# CITY OF ALBUQUERQUE

October 5, 2023

**Re: Panda Express**  
**2040 Gibson Blvd. SE**  
**Traffic Circulation Layout**  
Engineer's Stamp 09-12-23 (M15-D021F)

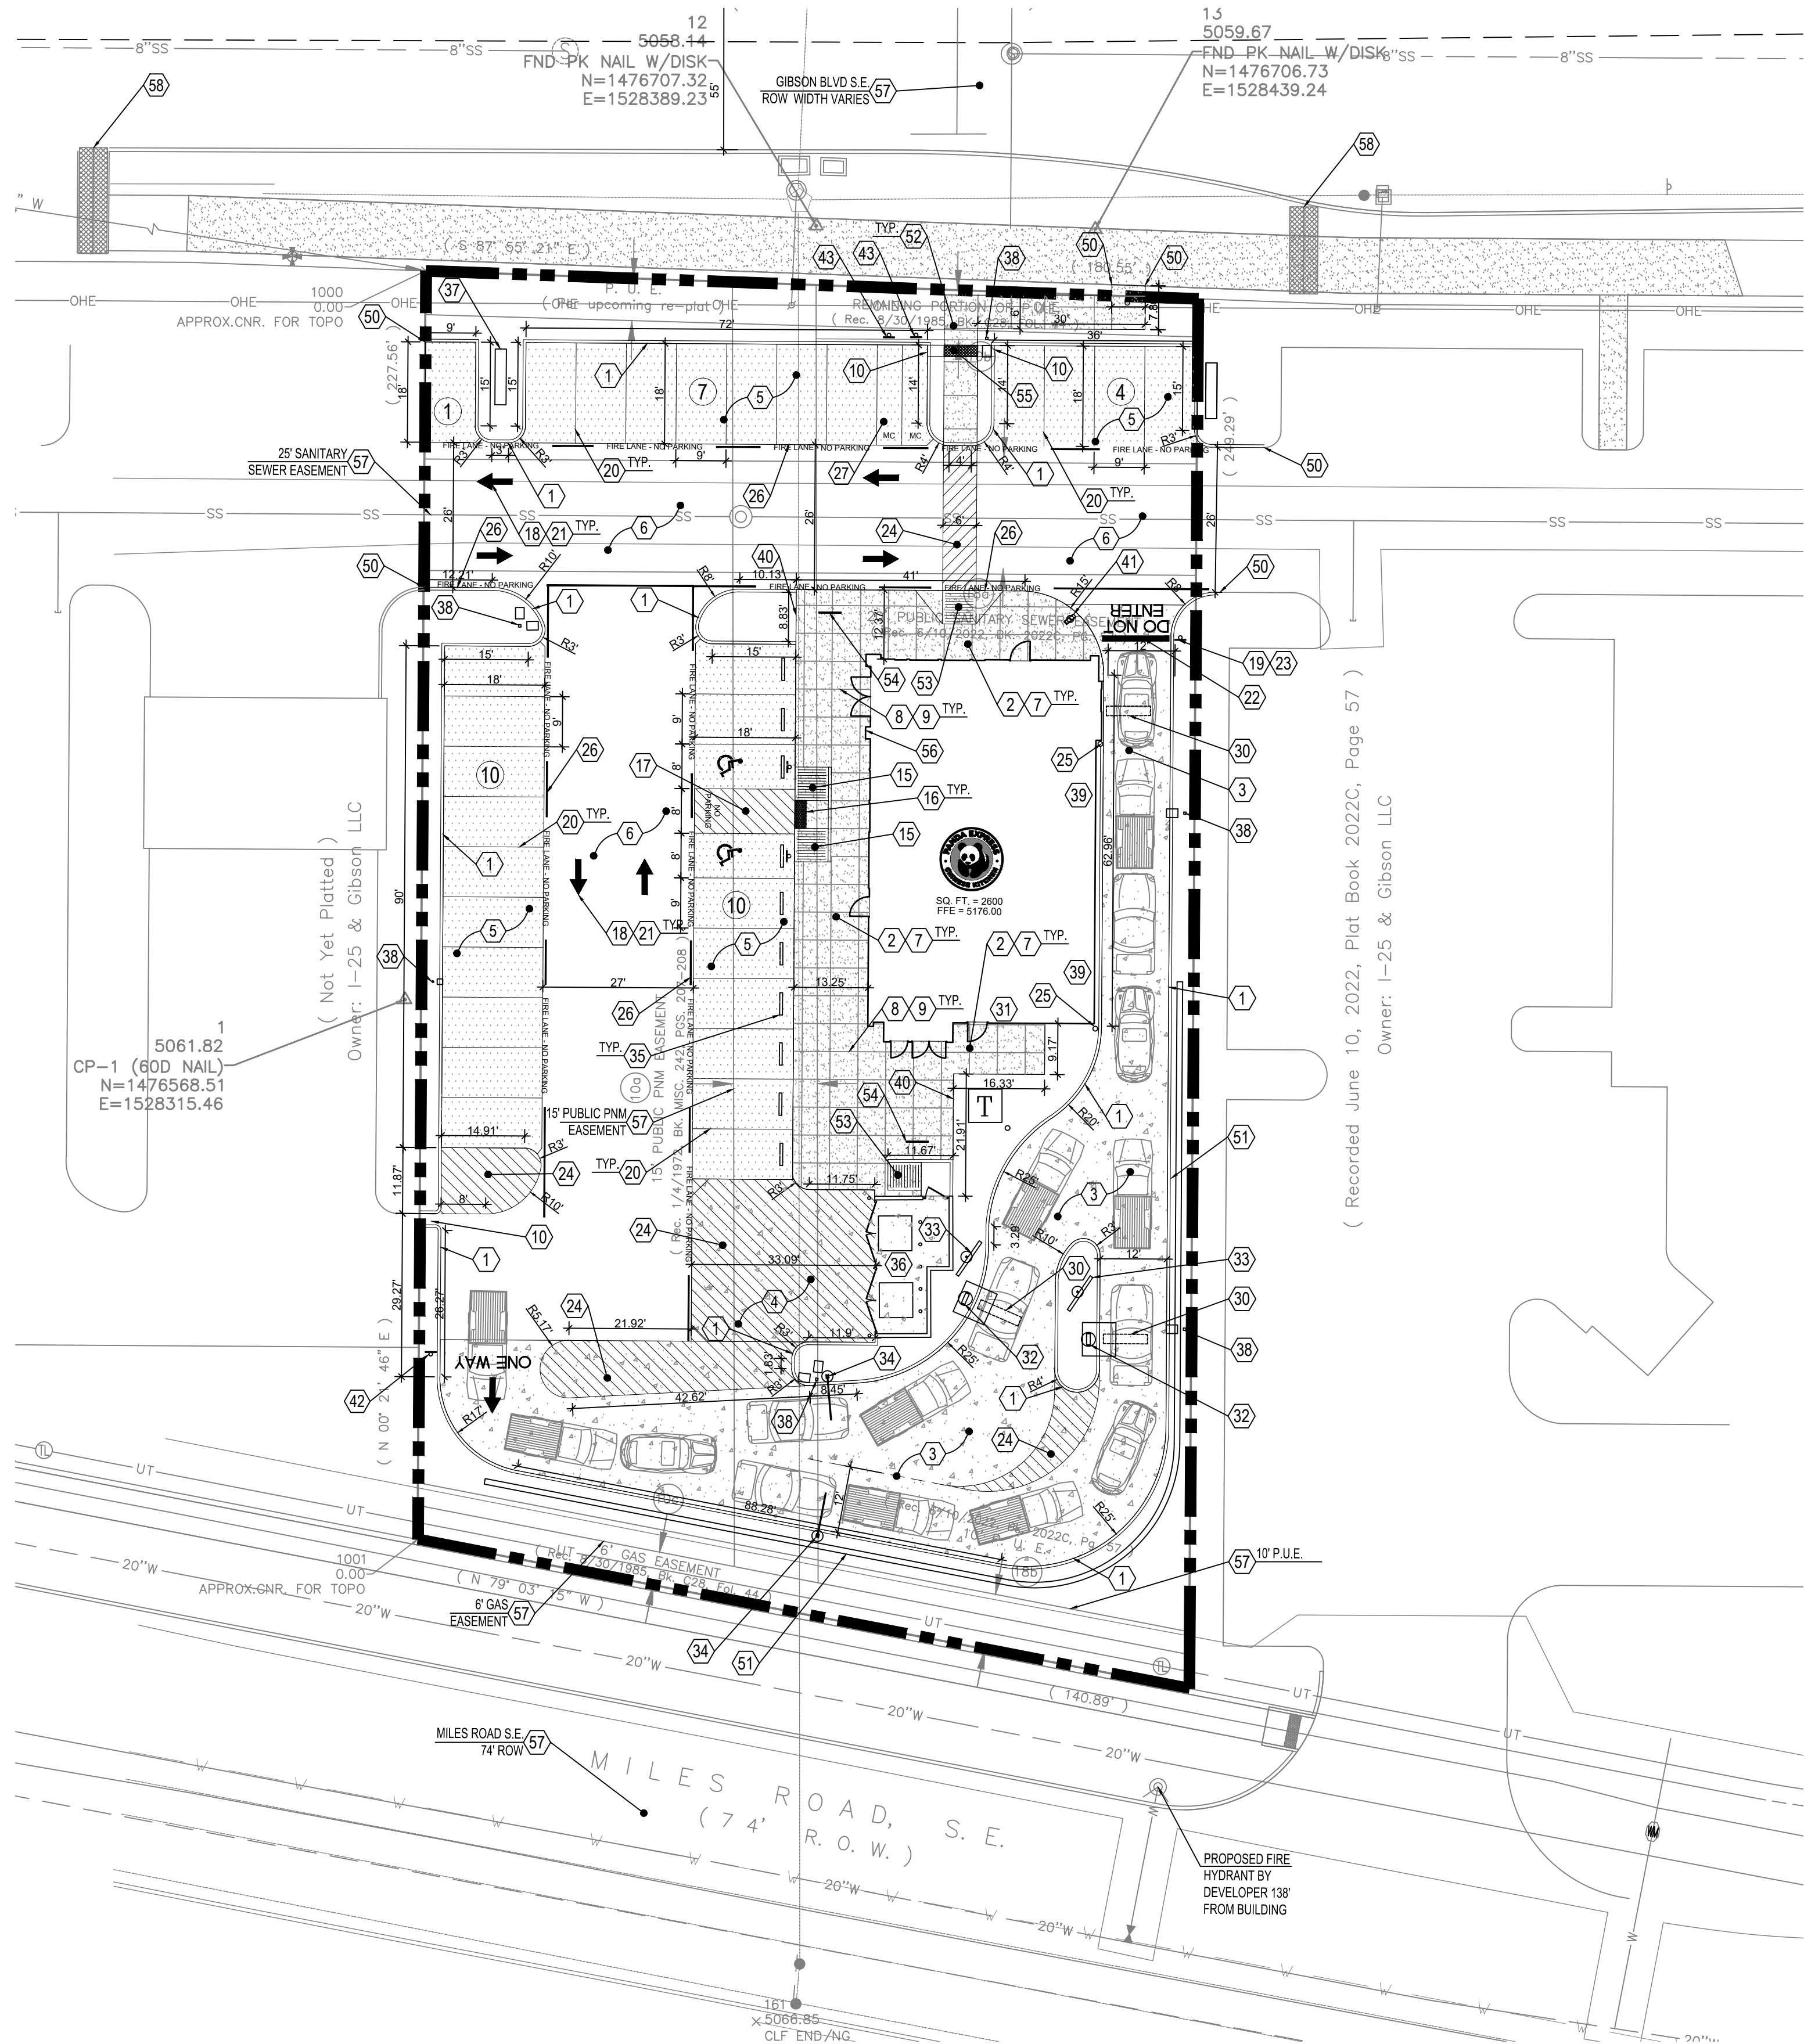
1. List the number of Motorcycle and Bicycle parking spaces required by the IDO.
2. Identify all existing access easements and rights of way width dimensions.
3. Identify the right of way width, medians, curb cuts, and street widths on Gibson Blvd. and Miles Rd.
4. Please provide a copy of Shared access agreement.
5. Show on the site plan the drive-thru lanes width.

Albuquerque

NM 87103

www.cabq.gov

11. The pavement marking "MC" should be shown in the opposite direction for motorcycles entering the parking space.
12. Please provide "One Way" signage and pavement markings, at the beginning of the drive-thru lane. Please show detail and location of posted signs and striping.

13. Refuse vehicle maneuvering shall be contained on-site. The refuse vehicle shall not back into the public right of way.; provide a copy of refuse approval.

MOTORCYCLE PARKING
SIGN DETAIL

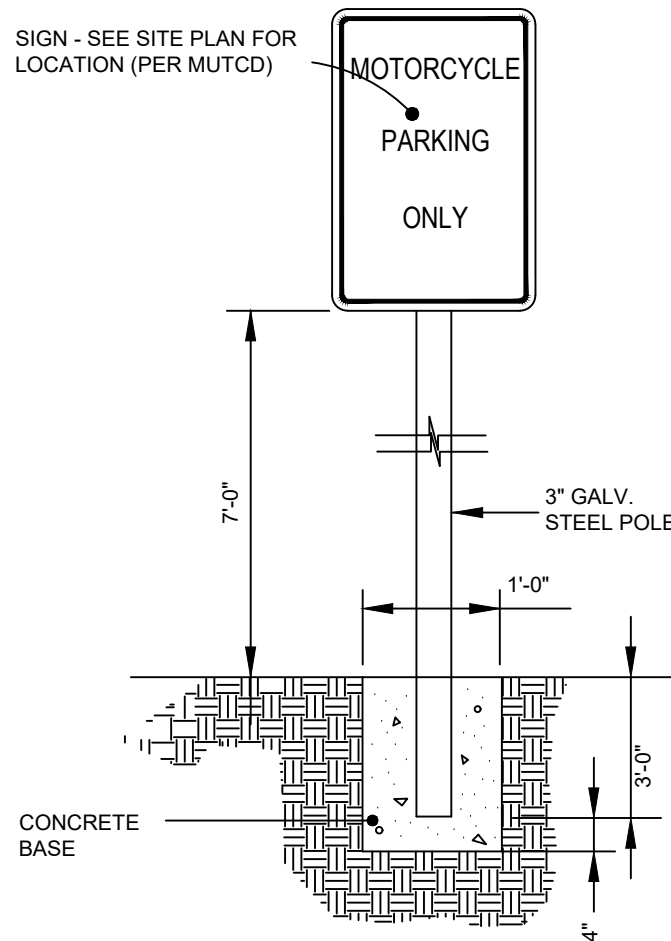
9. Please remove the Retaining Wall details from sheet C03.2.
10. Motorcycle parking spaces shall be designated by its own conspicuously posted upright sign, either free-standing or wall mounted per the zoning code.
